Re: 31 Derby Road

I have now received the comments of the highways officer which require the following amendments to be made to the submitted plans:-

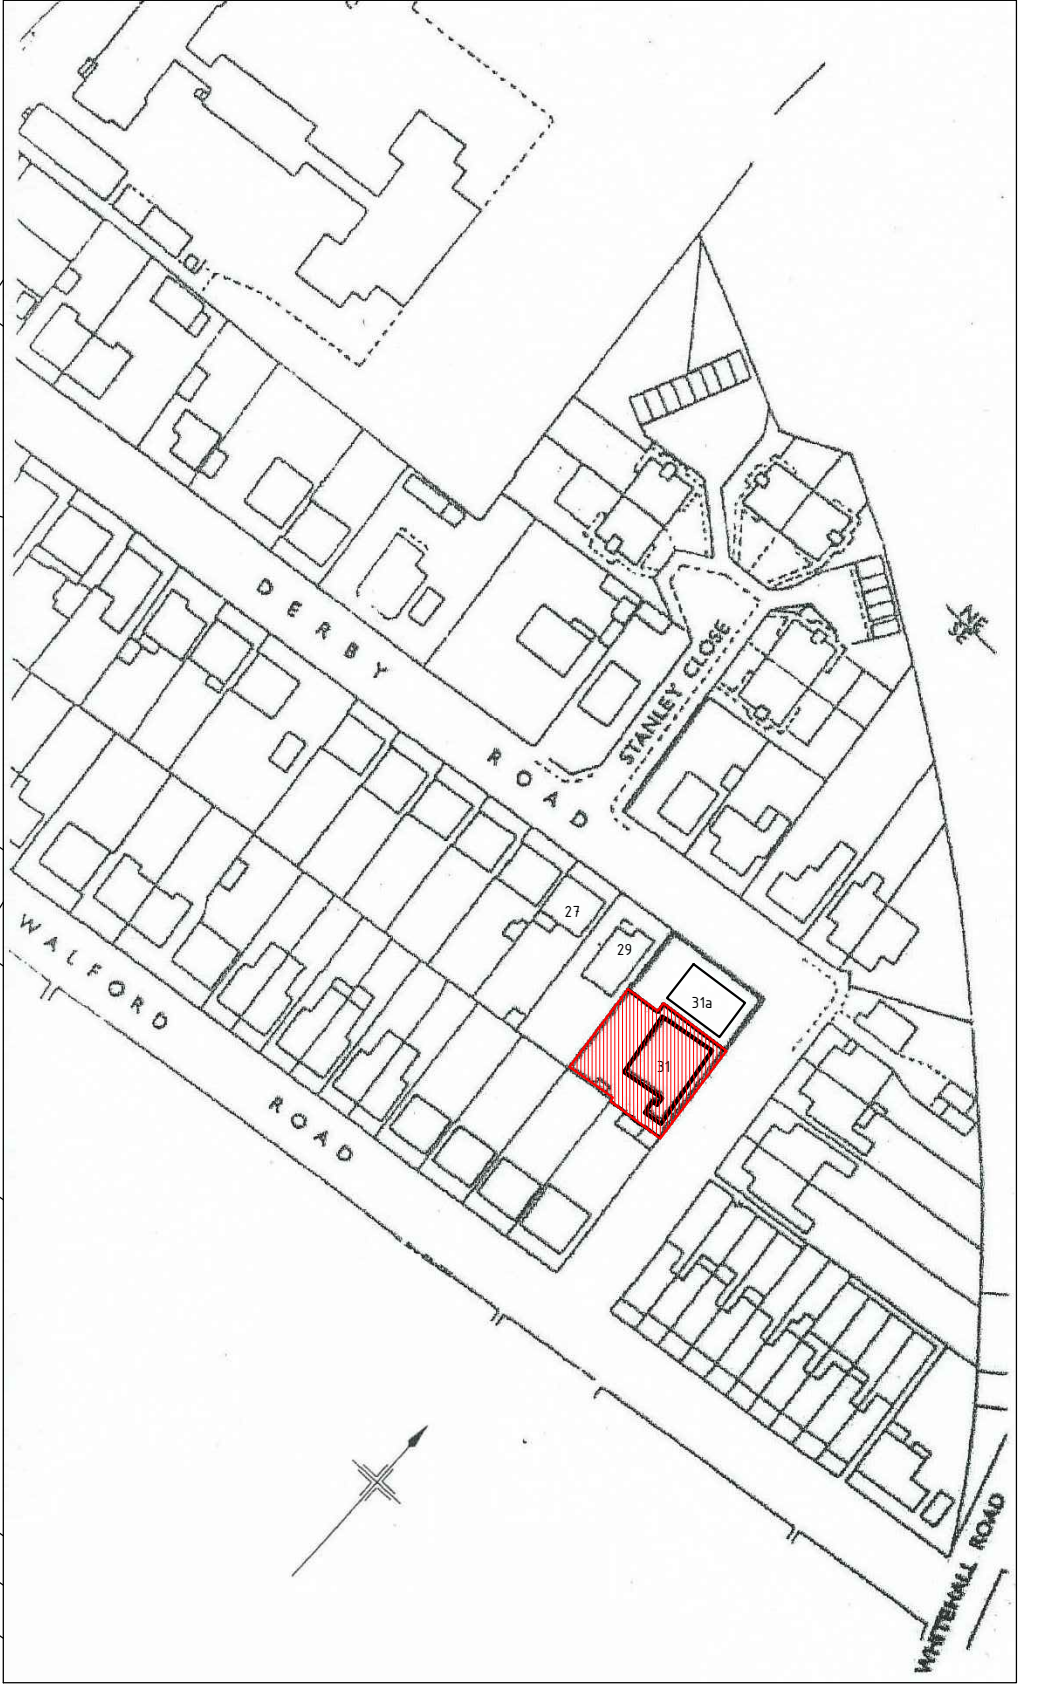
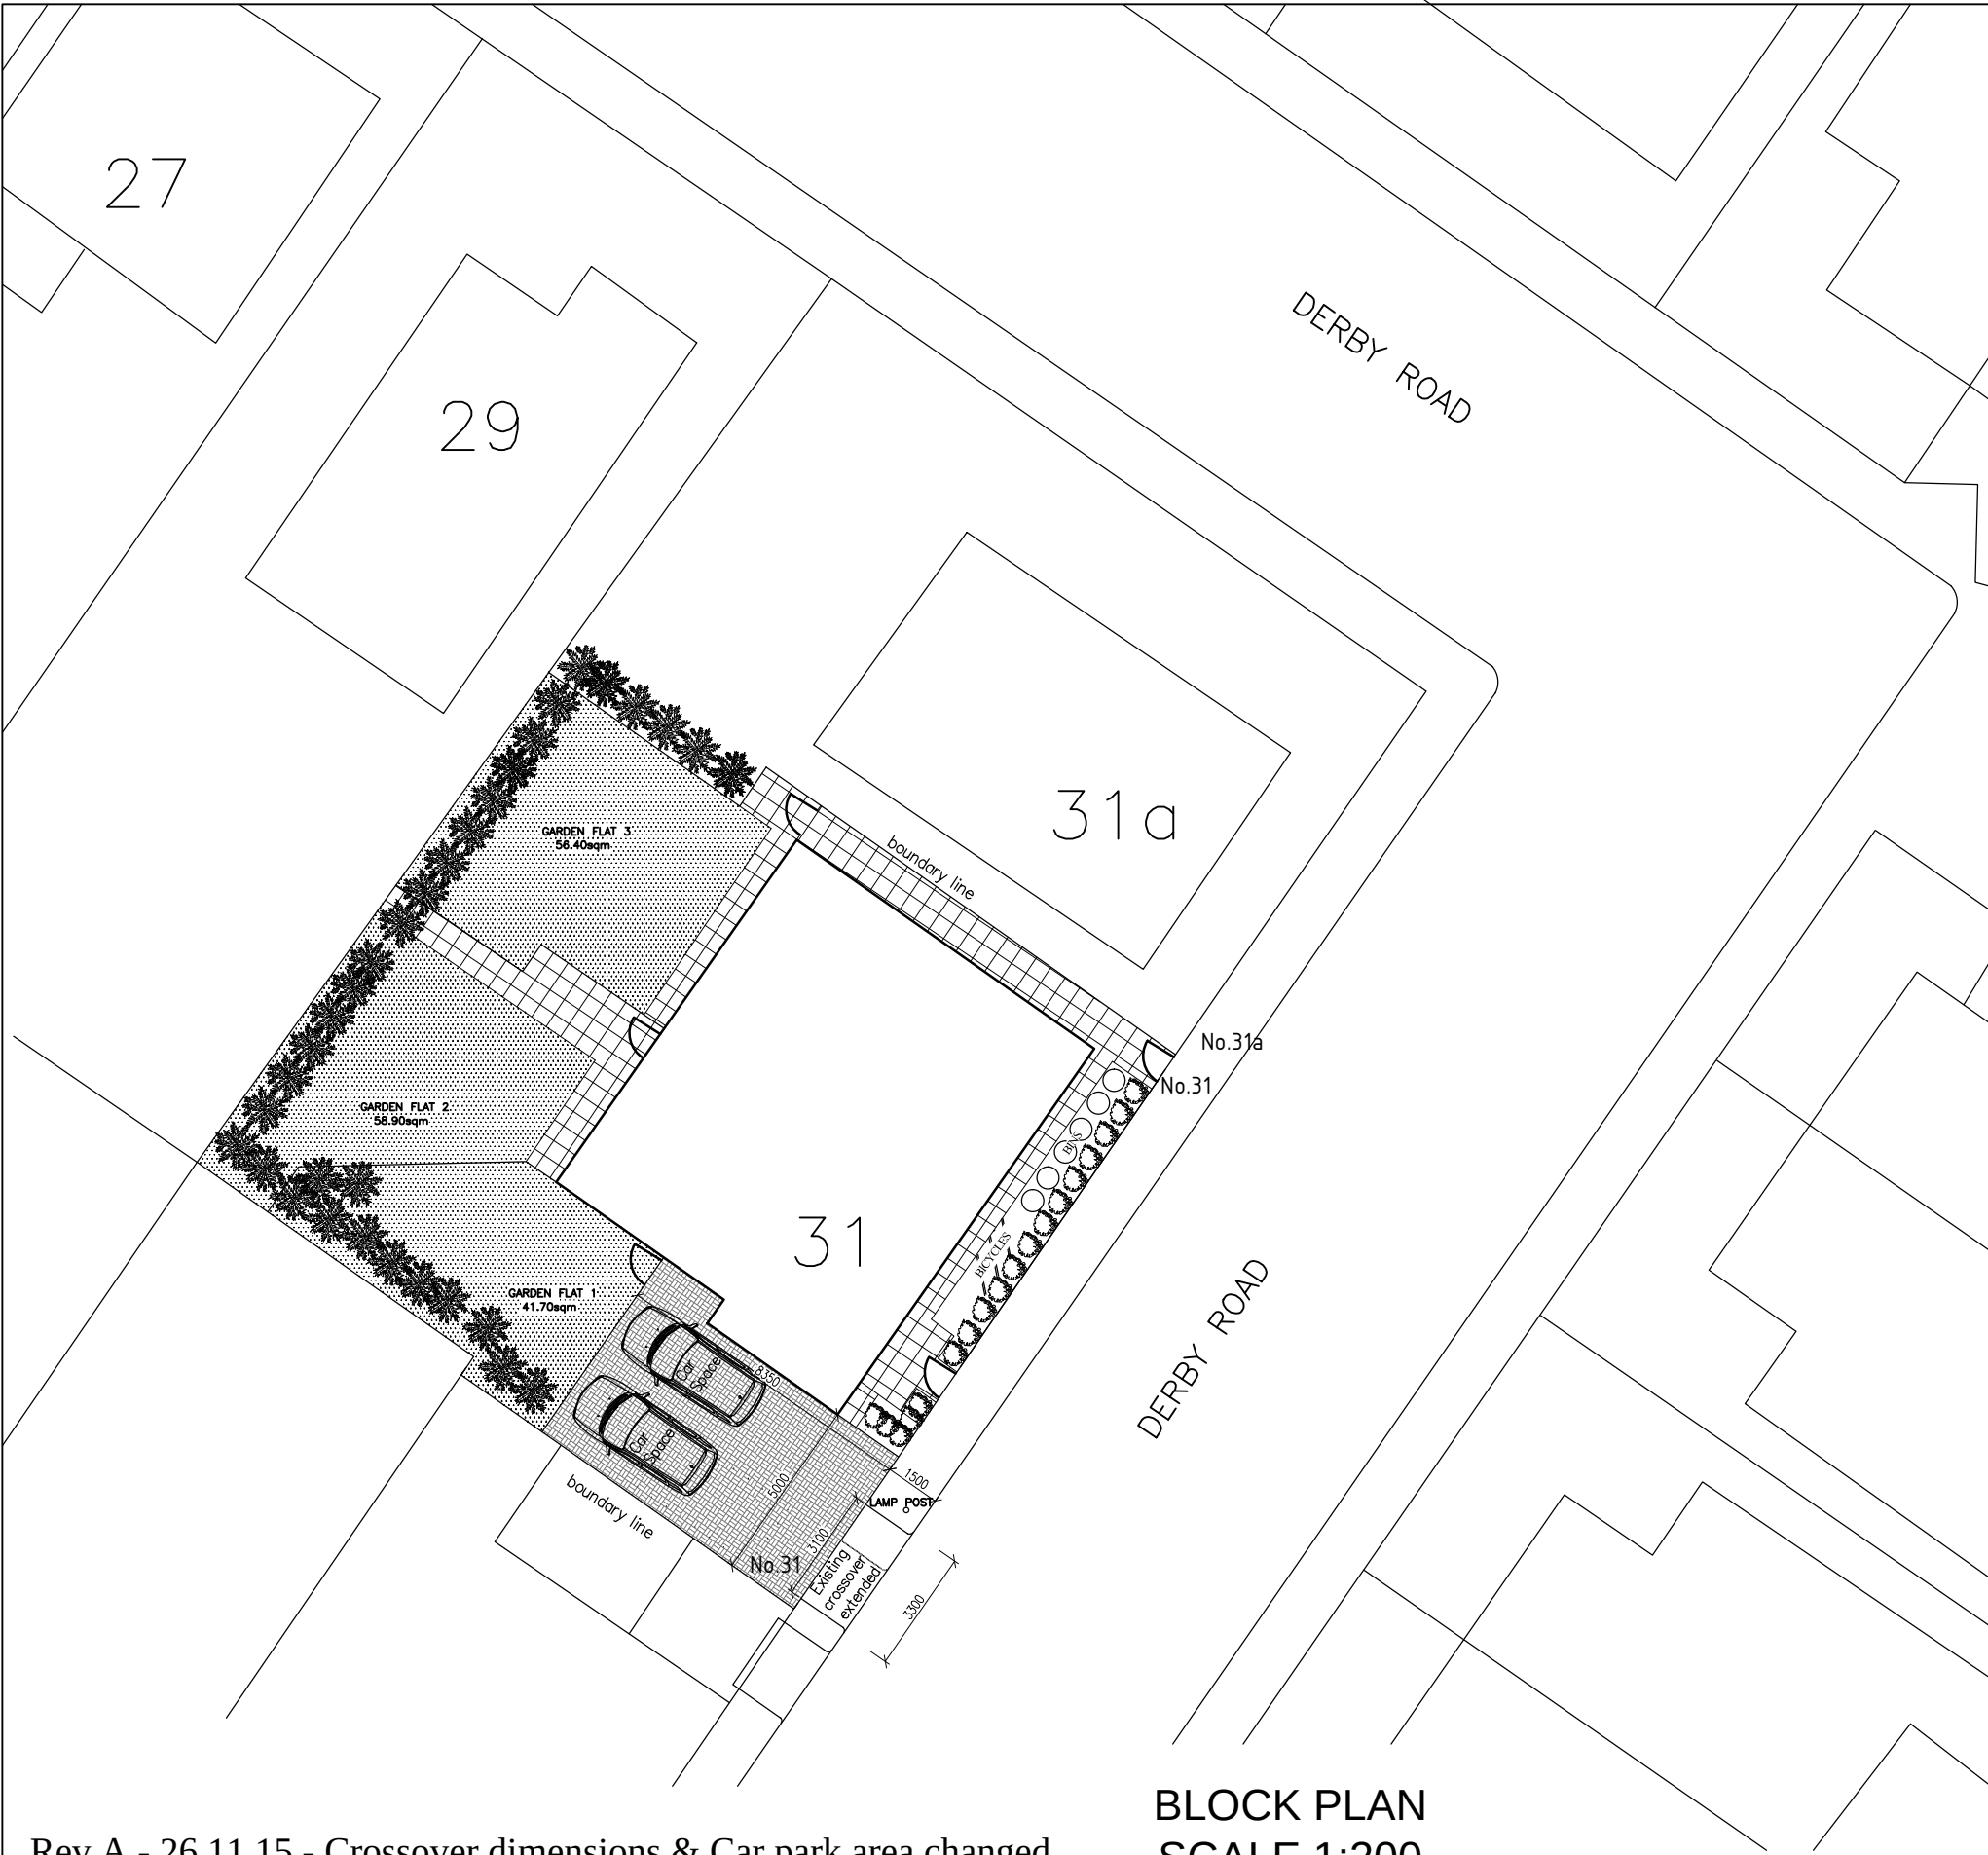
1. Pedestrian visibility splays measuring 1.5x x 1.5m should be provided (at the back of footway) to the vehicular access.
2. The proposed widened crossover should be centralised across the 5m space for the two car park bays. This may require the lamp column to be relocated or the widening of the crossover to be reduced. Please see attachment for form of LBH standard residential vehicular crossover. The applicant will be responsible for all the costs of the crossover.

Please see the attached drawings showing amendments to the proposed crossover in line with the comments in your e-mail. I have accommodated all the points, however, there is very little we can do with regards to the existing garage wall on the boundary line with the adjoining property.
